Engineers Comments Regarding Surface Water Drainage

Application Reference:	BN/33/26/PL	Reviewer Reference:	ADC/EXT4b
Planning Officer:	Amber Willard	Date of Review:	23/07/2026
Site Name:	Land South of The Hollies 84 Barnham Road Eastergate PO22 0ES		
Application Description:	Construction of 2 No C2 (residential institution) dwellings and associated works (resubmission following BN/125/25/PL). This application may affect the setting of a listed building and is in CIL Zone 2 and is CIL Liable as new dwellings.		
Assessment Number:	1

7.2 **Appendix B – Drainage Layout**

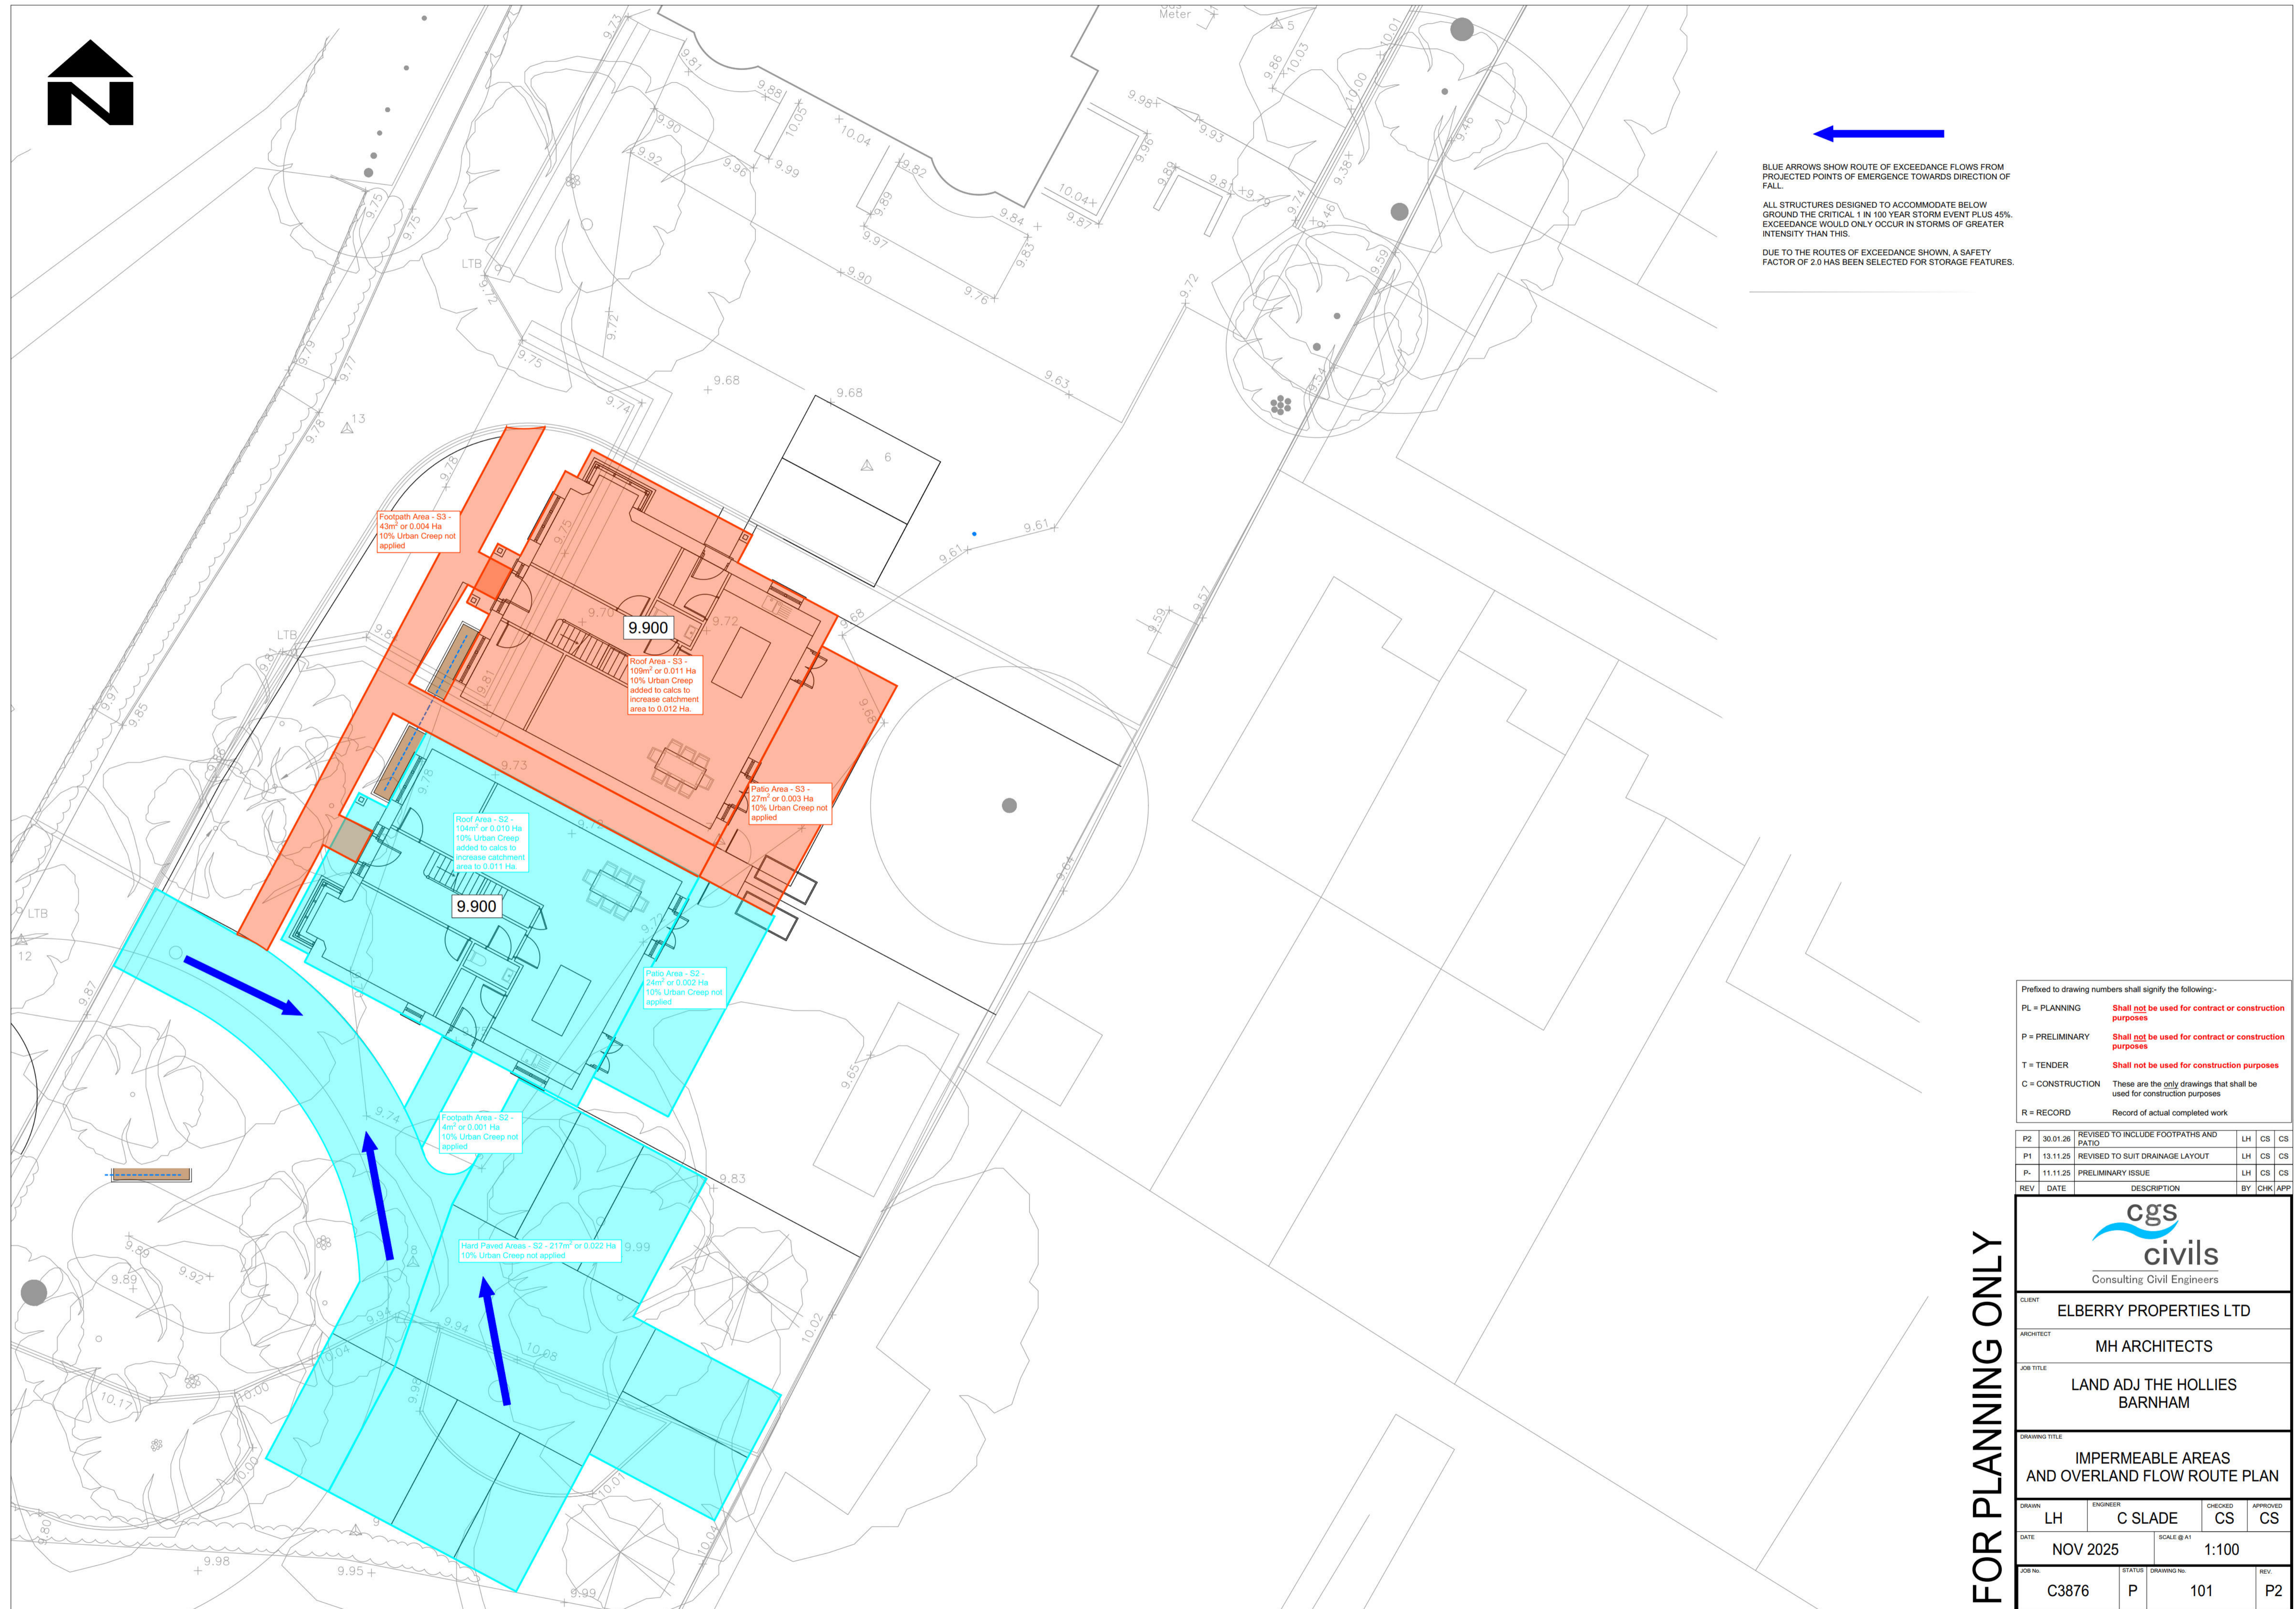
- 3.1. The proposed discharge rate of 0.5l/s is higher than the target 50% AEP greenfield runoff rate (0.1l/s) or 3l/s/ha (0.135l/s). However, reducing the discharge rate to either of these would increase risk of blockage and therefore increase risk of flooding onsite. To achieve the proposed discharge rate a vortex flow control is proposed, the diameter within this is 20mm. Where an orifice of less than 50mm is required to achieve the peak allowable discharge rate then the flow control should be robustly protected from blockage risk and the risk of blockage assessed and mitigated against. Leaf guards are now proposed at the rainwater pipes to further reduce risk of blockage. Maintenance and additional measures can be considered via a suitably worded condition.

- 3.2. It is unclear if the outfall is likely to be surcharged as no information regarding its capacity has been submitted. If surcharging is likely, then this should be modelled to demonstrate that the system will still perform as designed under those conditions.

- 3.3. The connection to the existing surface water sewer relies on crossing third party land. As drawn, this is highways land (footpaths) and a greenspace owned by Arun District Council. Agreement in principle from the landowners has not been submitted. If consent is not granted it is unclear how the site will achieve a compliant surface water drainage design that does not increase flood risk as there are no obvious alternative disposal locations. **The planning officer should consider whether this should affect their decision**. In addition to the land ownership questions, as part of the detailed

design process the design may need to be modified to ensure that the outfall pipe does not clash with the foul network in Market Close. The levels of the foul network are unknown and will need to be researched and clarified by the designer.
